**Phase 1, South Site, Former Shredded Wheat Factory – Condition 50 (ref: 6/2019/1788/COND)**

I write further to Lorraine Davis' comments dated 29 July 2019, responses to which I have provided against each below.

PROJECT TITLE FORMER SHREDDED WHEAT FACTORY			
DRAWING TITLE PHASE ONE REFUSE COLLECTION BLOCK 11			
CLIENT / ARCHITECT METROPOLITAN			
STATUS			
SCALE 1:250	AT A3		DRAWN LL
CHECKED RF			APPROVED
DRG SIZE A3	DATE 10/19	DRAWING NUMBER SK202	REV B

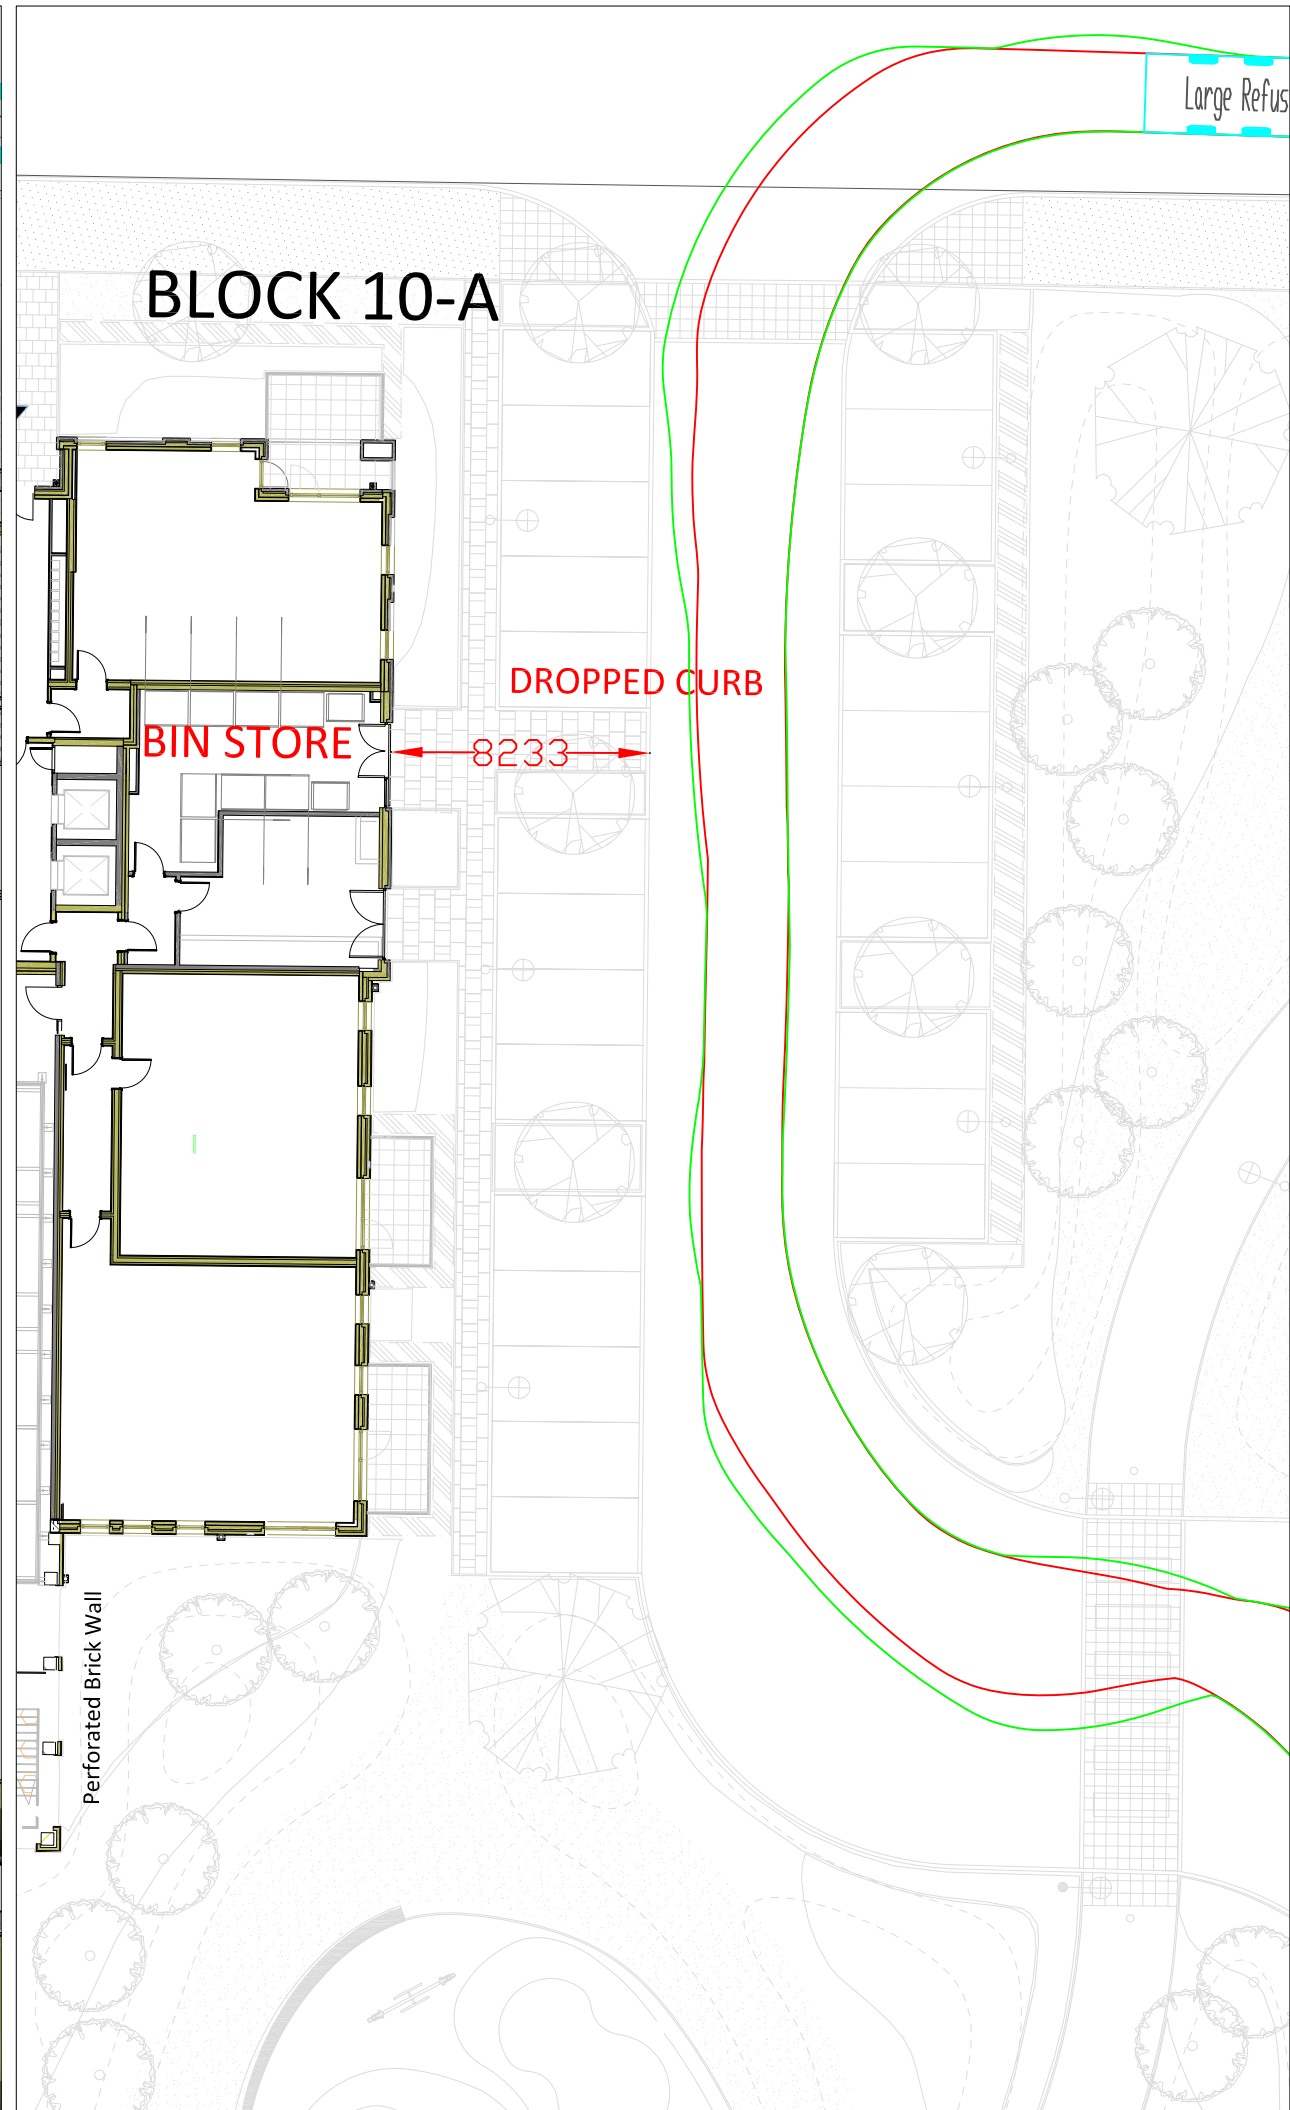
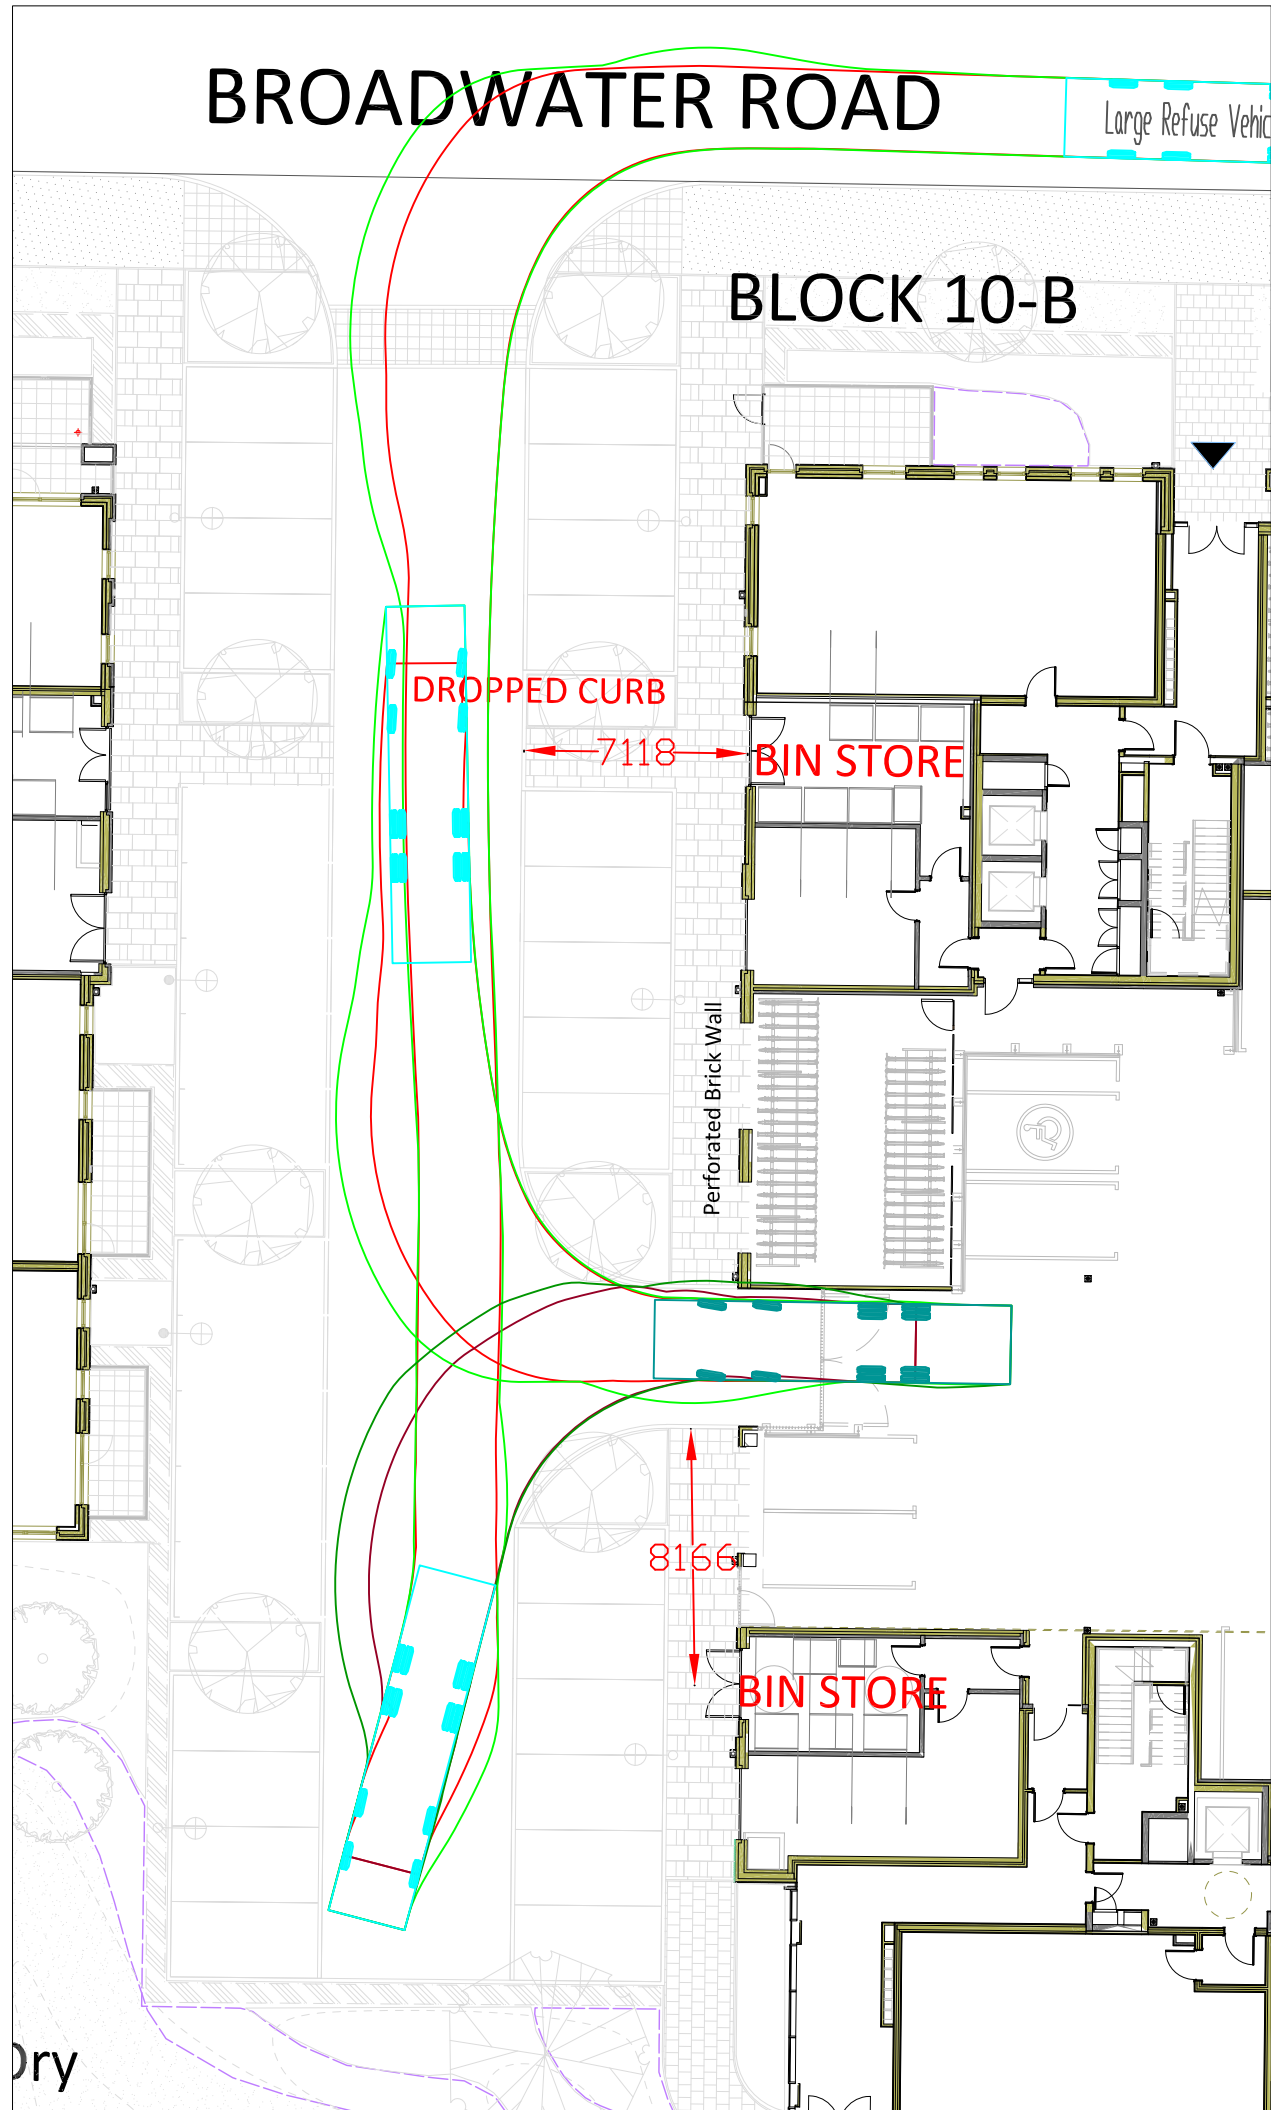
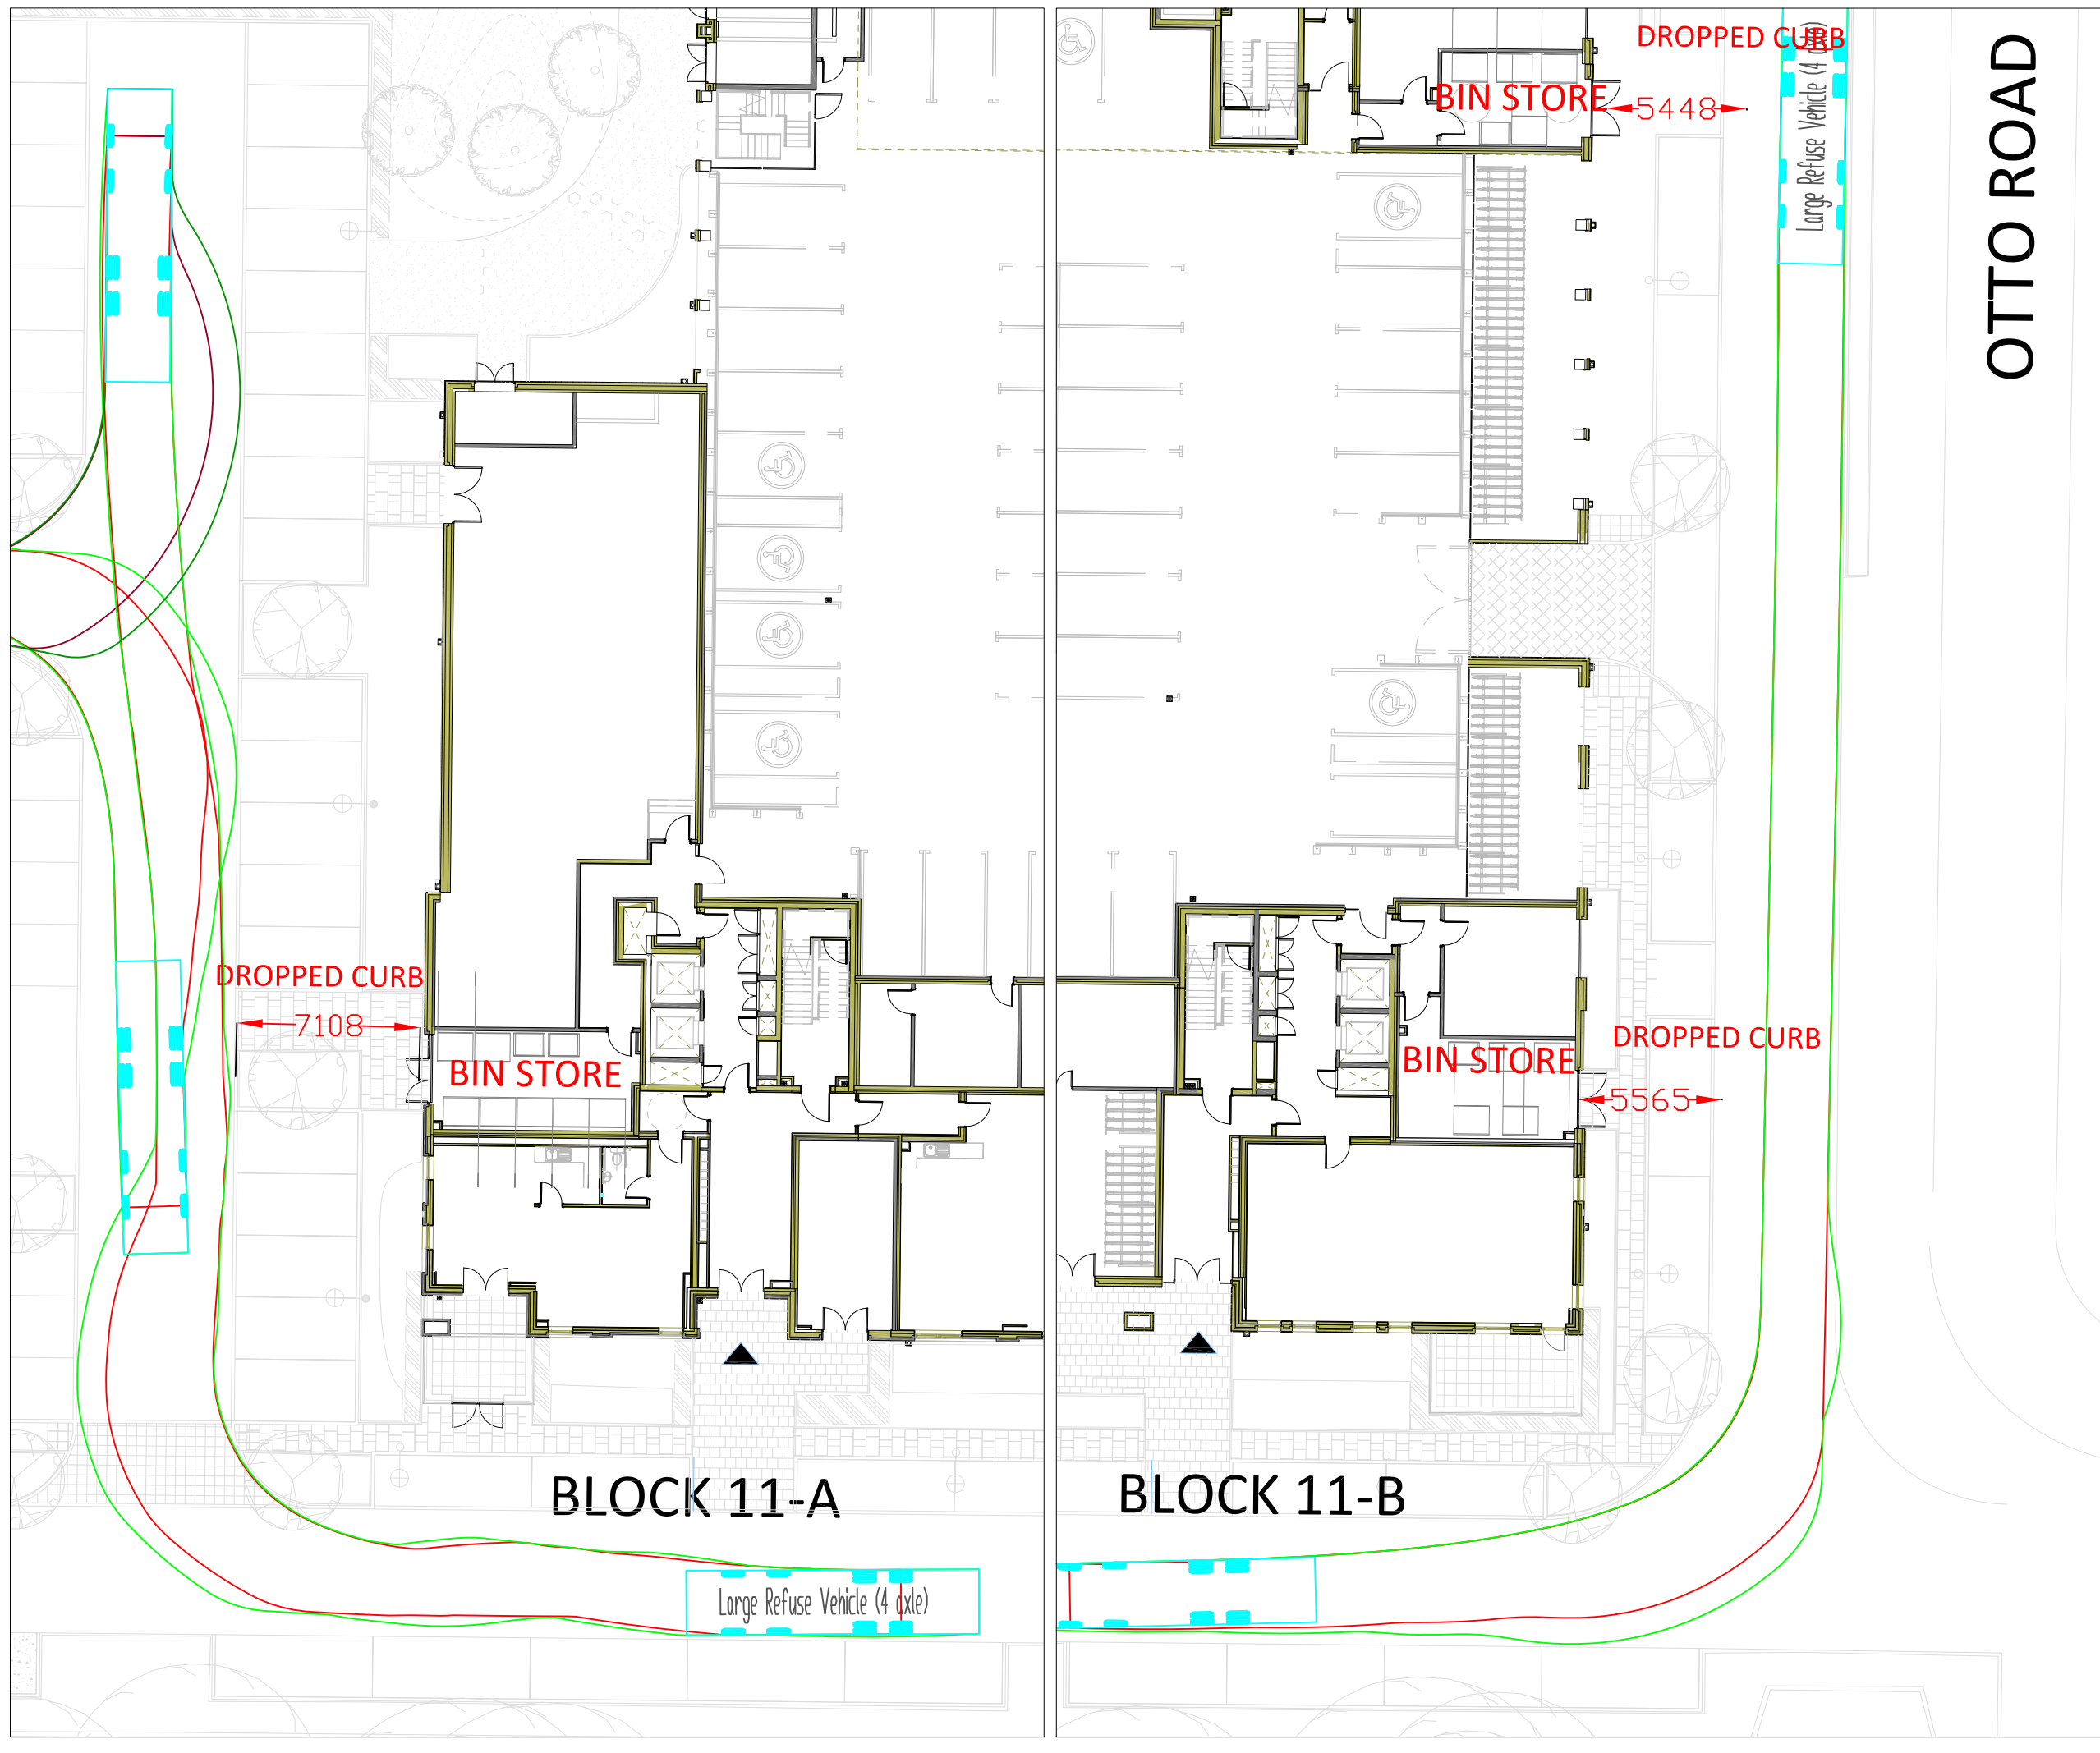
*“There is no provision for the MRC's (Mini Recycling Centres). Block 10A and 11A will require 2 MRC's each and 10B/C and 11B/C will require 1 each. Can you please supply diagram with drag distances from bin store to freighter annotated on. These are to be no more than 15m, however, our preference is 10m”*

*“Please confirm that there will be dropped kerbs and minimum 2m wide smooth paths from store to freighter with no steep gradients as noted on the original application.”*

Please find enclosed the following plans which include accommodation of the requested number of MRCs within each block and annotations of acceptable drag distances:

Please find enclosed a Delivery and Servicing Plan prepared and submitted pursuant to condition 24. This Delivery and Servicing Plan confirms the necessary access between bin stores and freighters for each block, reflecting the arrangements illustrated within the above plans and including the use of dropped kerbs and acceptable gradients.
